CITY OF ALBUQUERQUE

September 27, 2010

Re: Certification Submittal for a Temporary Building Certificate of Occupancy
(C.O.) for Coors Park & Sell, [J-11 / D032]
730 Coors NW
Engineer's Stamp Dated 09/20/10

PROJECT TITLE: COORS PARK & SELL ZONE MAP/DRG. FILE #: 211 / D032
DRB #: _____ EPC#: 09EPC-40038 WORK ORDER#: _____
09EPC-40037

GRADING AND DRAINAGE PLAN

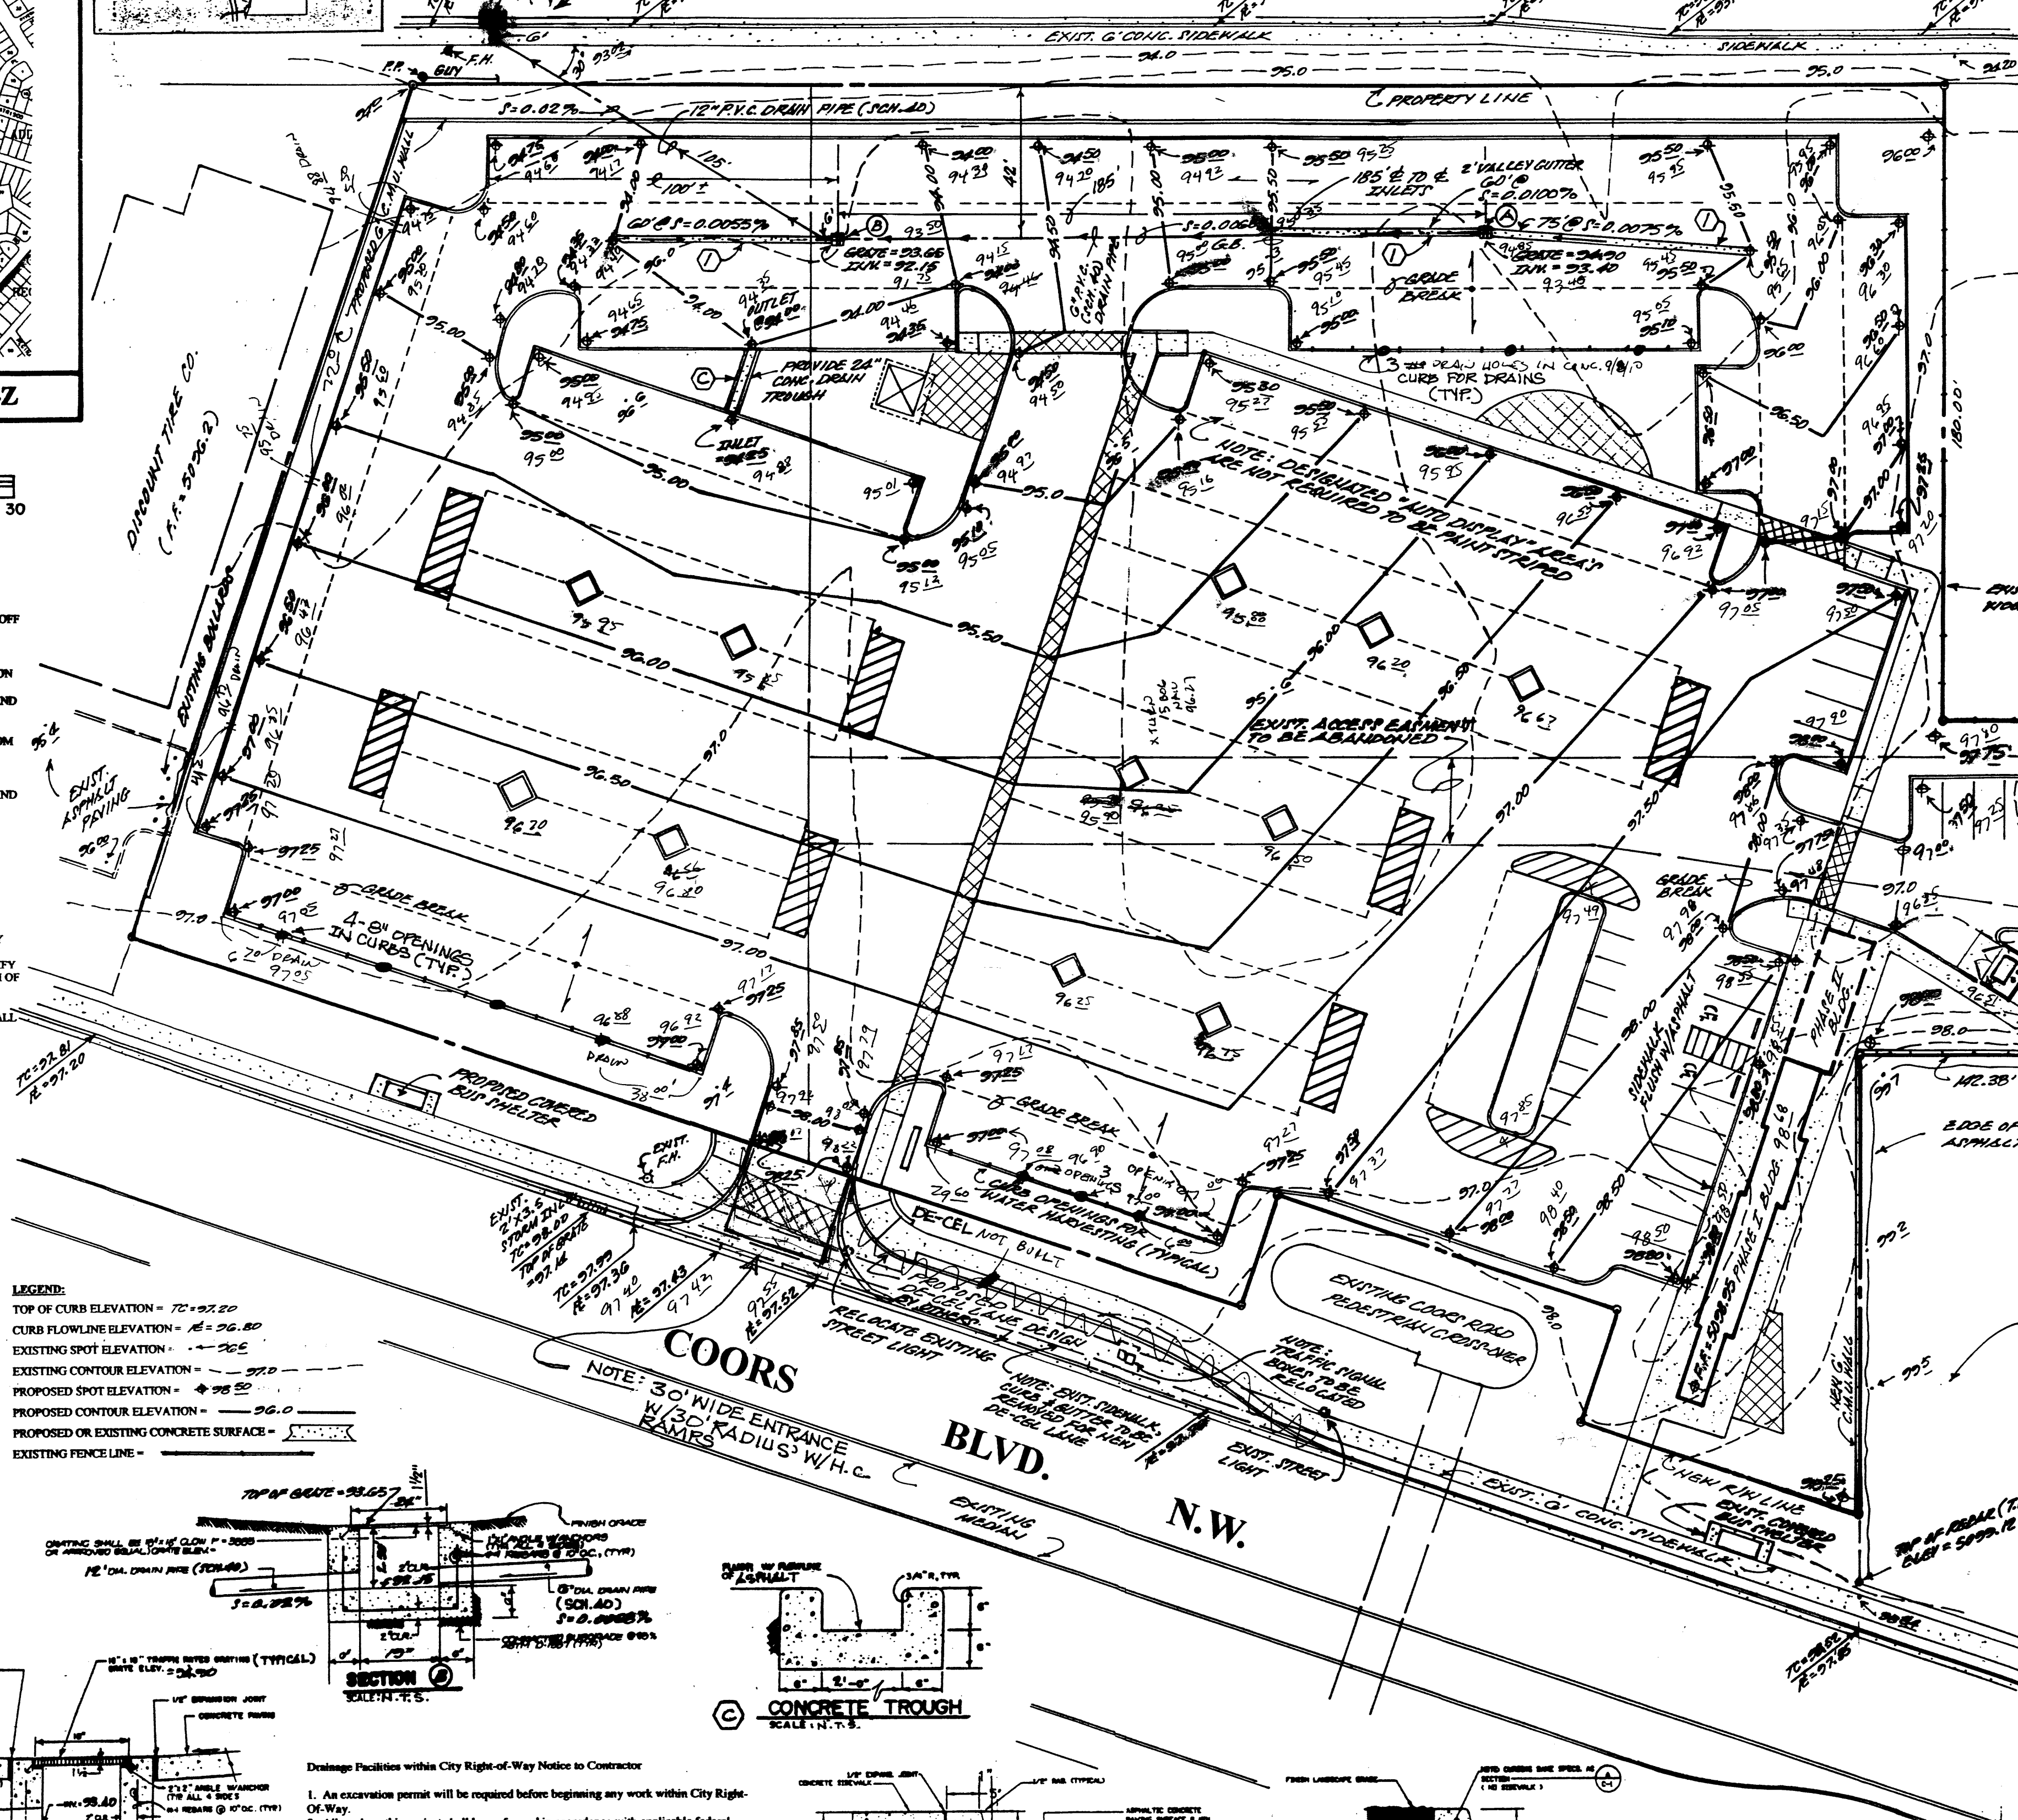
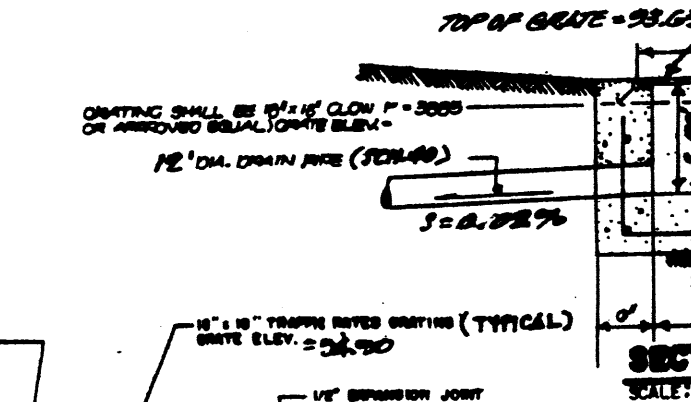
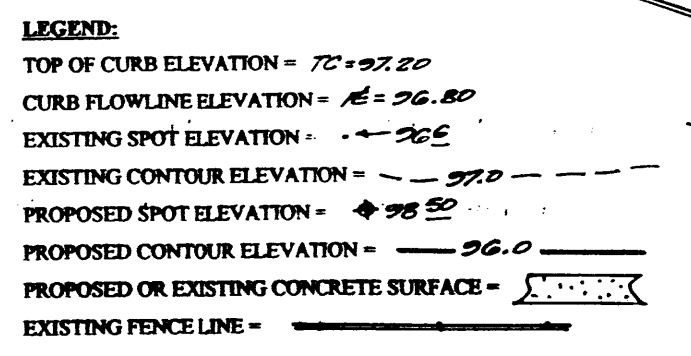
However, the above referenced plan cannot be approved for Site Plan for Building Permit or Preliminary Plat action by the DRB until the following comments are addressed:

- The plan proposes to modify a Type C or Type A inlet to a Type D inlet in Coors Blvd. Per the DPM, if a Type A or Type C inlet is changed to a Type D, then an equivalent inlet must be added to maintain system capacity.

- Runoff calculations provided show an increase of 4.43 cfs from existing condition to proposed condition. However, existing contours show that this site currently ponds, so the increase in runoff would be greater than 4.43 cfs.

- There is a large flood plain north and east of this site, which this site drains to. Hydrology would like this site to have free discharge; however discharge from this site must enter the storm drain at the northeast corner of this site in Estancia Dr. An onsite storm drain is required, as discussed. Consider the offsite basins contributing to the above referenced inlet when determining capacity.

- EPC conditions include "Curb notches shall be added to the large, long planters along Coors Blvd, Estancia Dr., the entrance along Fortuna Rd, and the triangular area by the old gas station to allow runoff water to be used for supplemental irrigation purposes. Portions of the site should drain into these landscape areas, but they should not spill over the sidewalk.
